Our Ref: ID 3634
Your Ref: SSD-38358962

State Significant Development Application for Keri Keri Wind Farm (RTS)

Peter Cinque
Senior Manager, Emergency Risk Management
NSW State Emergency Service

B-1

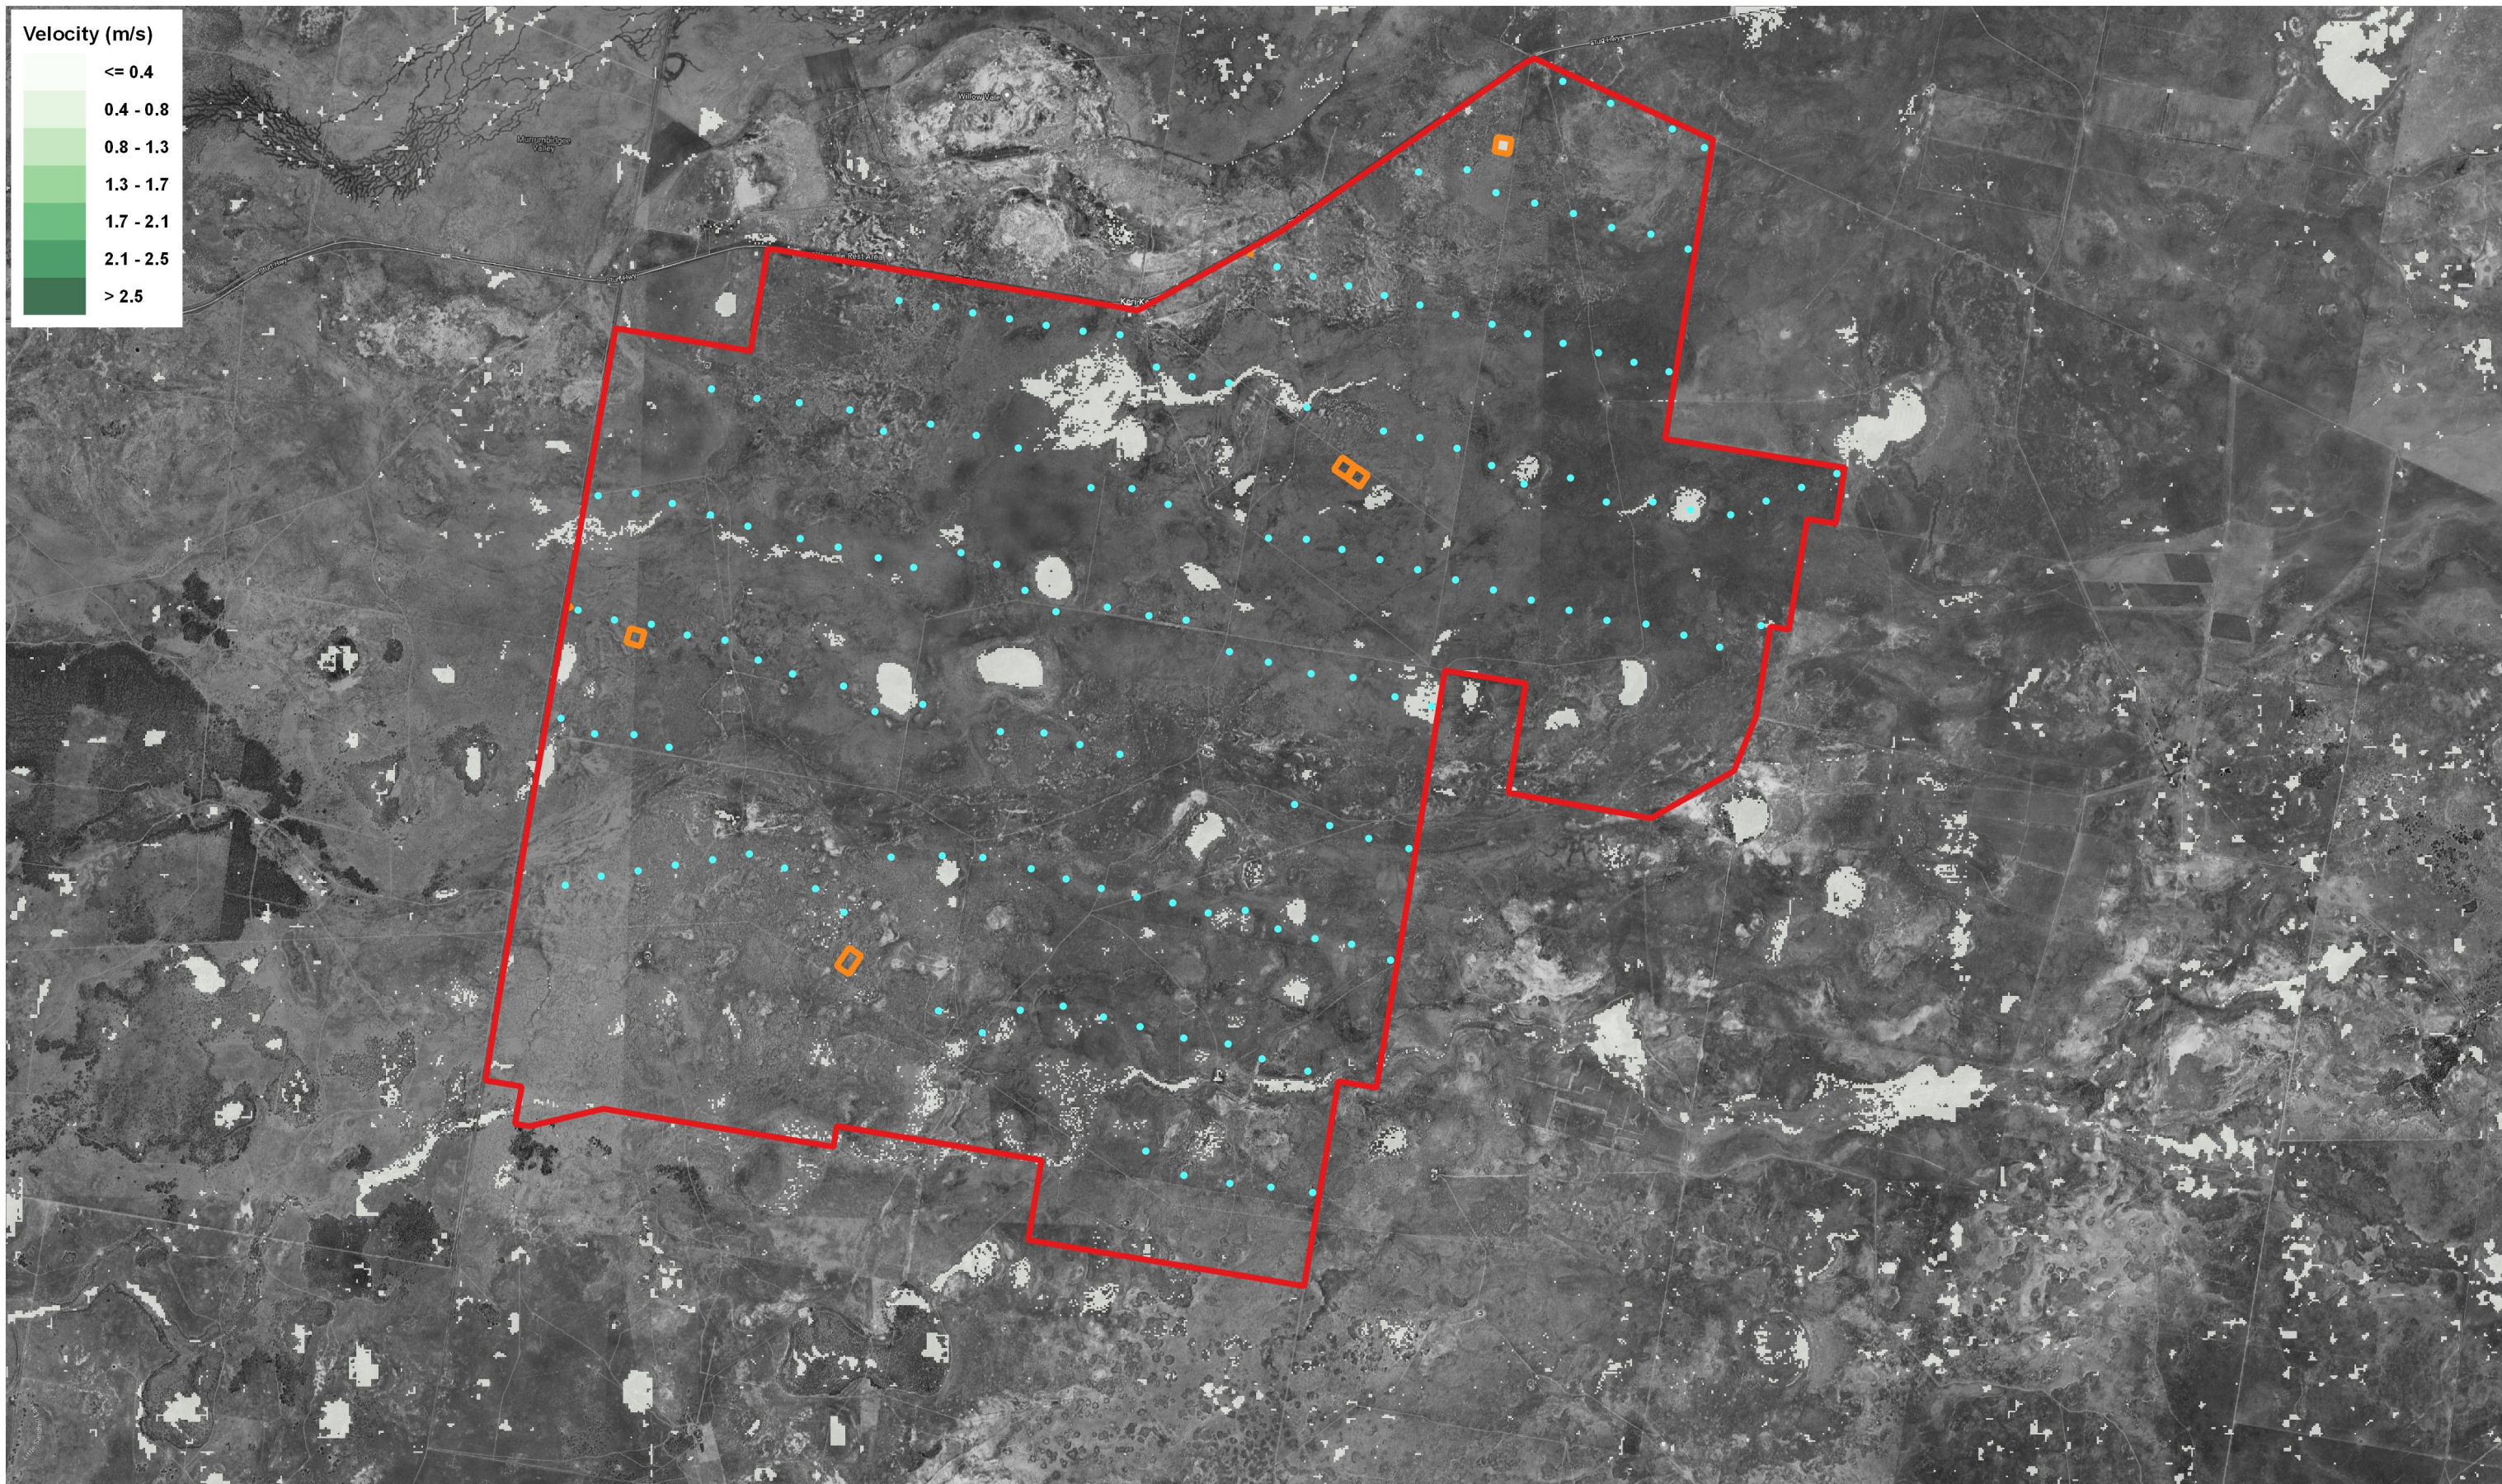
It is noted that the site itself is bounded by Abercrombie Creek to the south and is affected by breakout flooding from the Murrumbidgee River system. The site is affected by flooding as frequently as the 5% Annual Exceedance Probability (AEP) event with several shallow flow paths crossing the site.⁶ During the Probable Maximum Flood (PMF) event the majority of the site becomes inundated becoming a Low Flood Island. The Flood Report Addendum states *“Proposed developments are subject to depths of 0.5-1m, and Hazard Category H3. Depths of 1-2m and Hazard Category H4 are estimated at some WTG locations”*

⁶ BMT, 2025, Keri Keri Wind Farm Flood Assessment Addendum, Figure B-1 Keri Keri Developed Case 5% AEP Peak Flood Depth and Level, Page 35
